<b>Application Ref:</b>	3/2025/0892			 <b>Ribble Valley Borough Council</b> <small>www.ribblevalley.gov.uk</small>
<b>Date Inspected:</b>	25/11/25	<b>Site Notice:</b>	25/11/25	
<b>Officer:</b>	LW			
<b>DELEGATED ITEM FILE REPORT:</b>				<b>APPROVAL</b>

<b>Development Description:</b>	Proposed conversion from hairdressers with flat above to dwelling (Class C3) with annex accommodation and external alterations.
<b>Site Address/Location:</b>	5 Abbey View, Whalley Road, Billington, BB7 9NS.

A106 PROPOSED ELEVATIONS

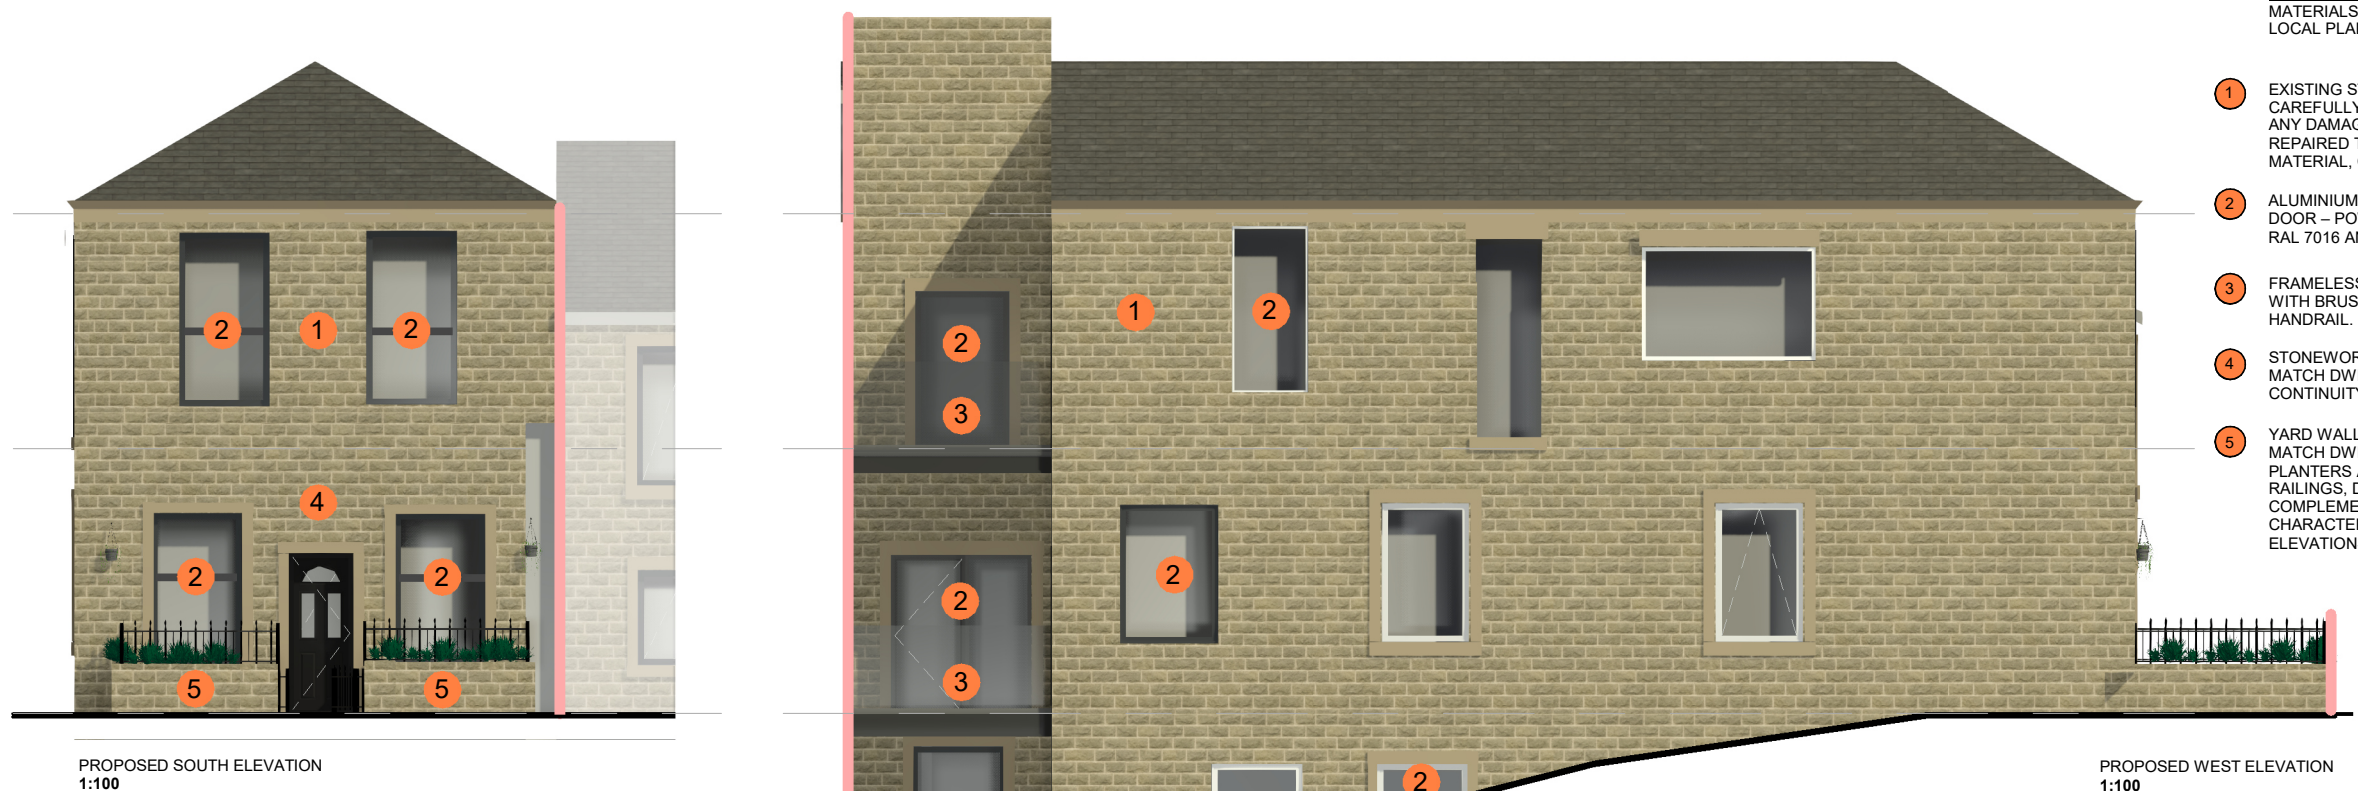
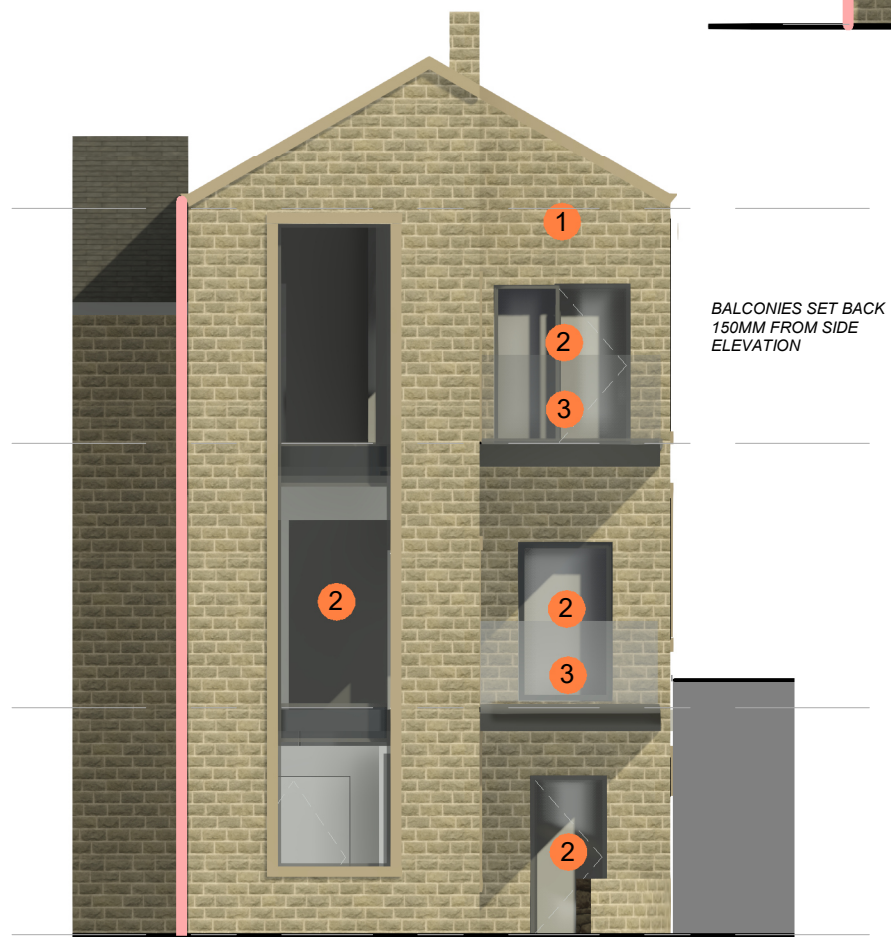
The openings to the eastern elevation of the application property face directly towards the private amenity space to the rear of the adjoined residential properties within the terraced row. The 2no. existing openings featured to the eastern elevation of the application property currently serve a lobby and WC which are non-habitable spaces; however, as part of the conversion works, the existing lobby window would be relocated with both windows shown to serve the kitchen/dining area. Given this would likely increase the perceived sense of overlooking experienced by the neighbouring residents and the fact that the proposed kitchen/ dining area would be served by multiple other window openings, it is considered that the 2no. windows to the eastern side elevation could be obscurely glazed in order to protect the amenity of the neighbouring dwellings without significantly impacting the amenity of the proposed dwellinghouse. This can be secured by an appropriately worded condition.

With the above in mind, it is not considered that the proposed development would result in any significant detrimental harm upon the existing amenities of any nearby residential receptors that would warrant the refusal to grant planning permission, subject to a condition requiring the openings to the eastern elevation to be obscure glazed.

Sheet No.
A105
PROPOSED FLOOR PLANS
Date 03/11/25
Current Revision 7
ISSUED FOR COMMENT

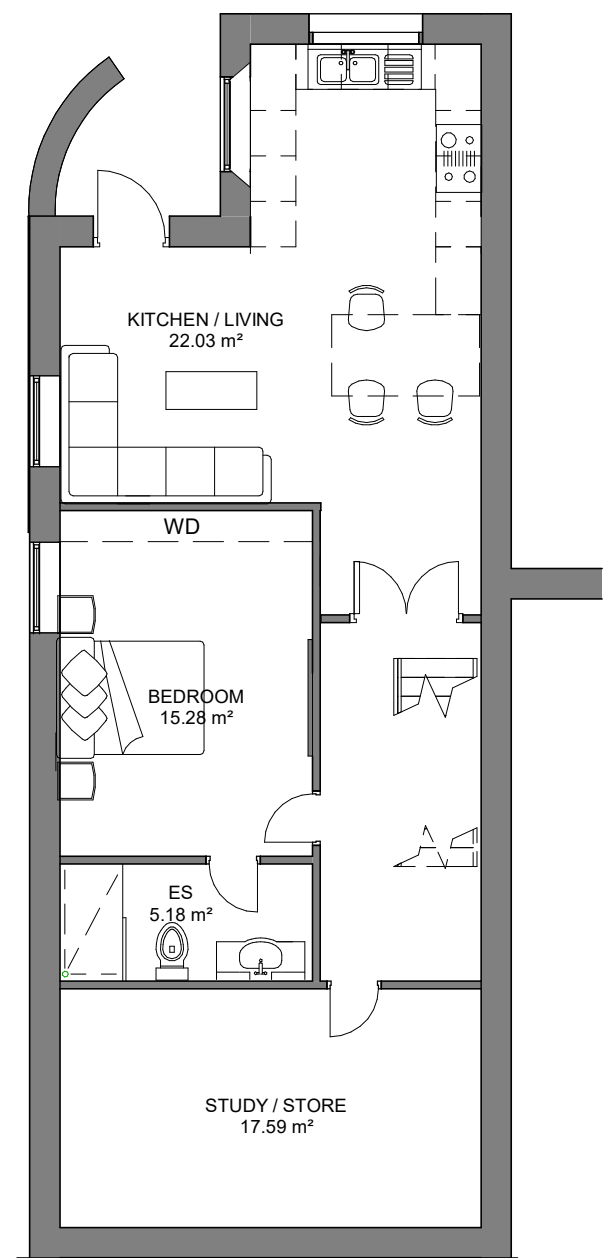
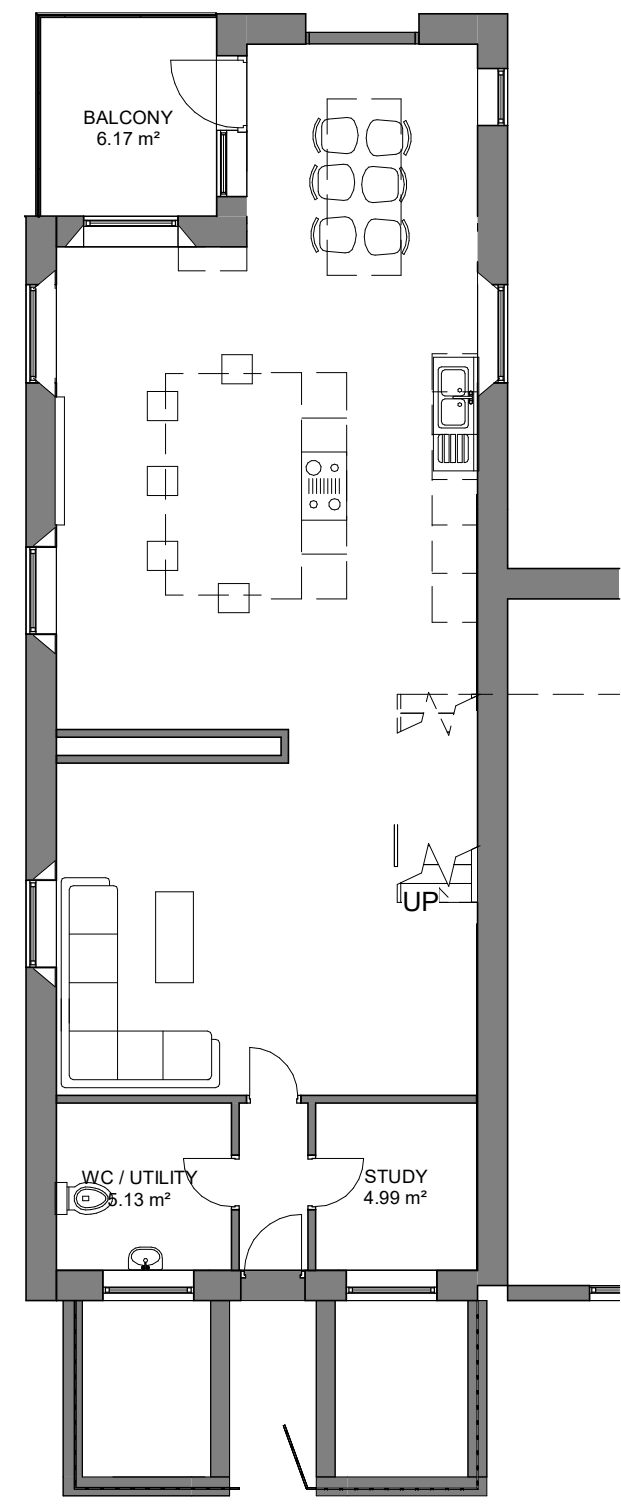
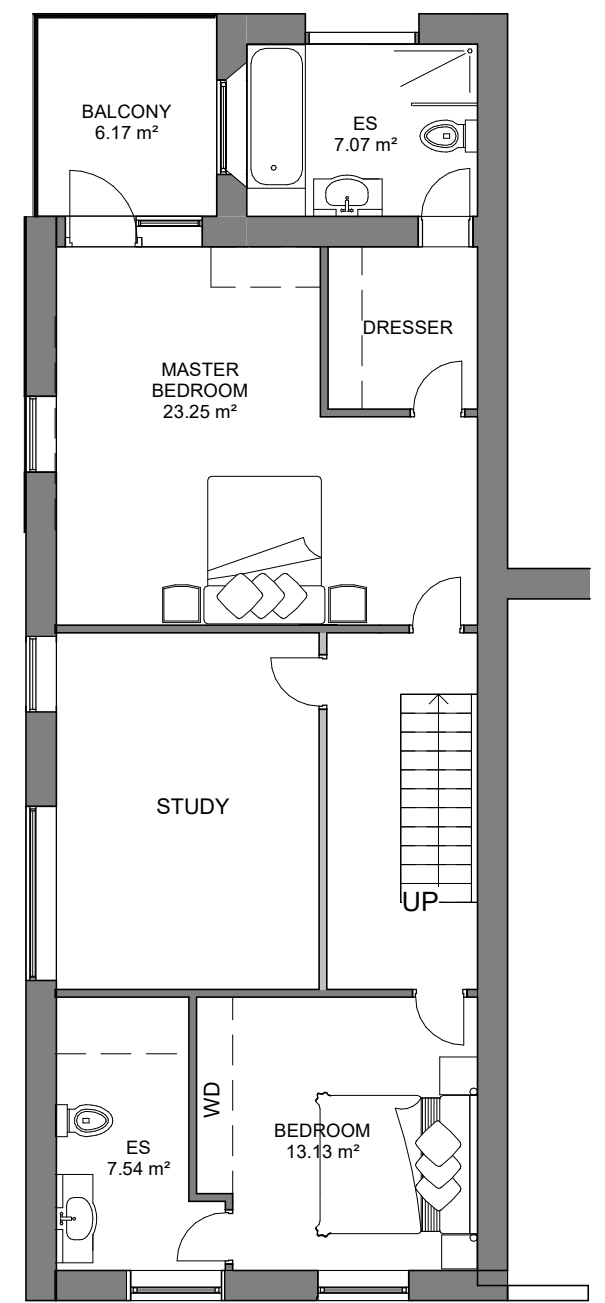
Concerns have also been raised with respect to the proposed floor plans showing two residential units (including two kitchens on separate floors). Following discussions with the agent, it has been confirmed that the lower ground floor of the property is to be utilised as ancillary annex accommodation and not a separate residential unit/ holiday let. The description of development has thus been updated to reflect this, and a condition can be attached to secure the lower ground floor as annex accommodation, ancillary to the main residential use of No.5 Abbey View.
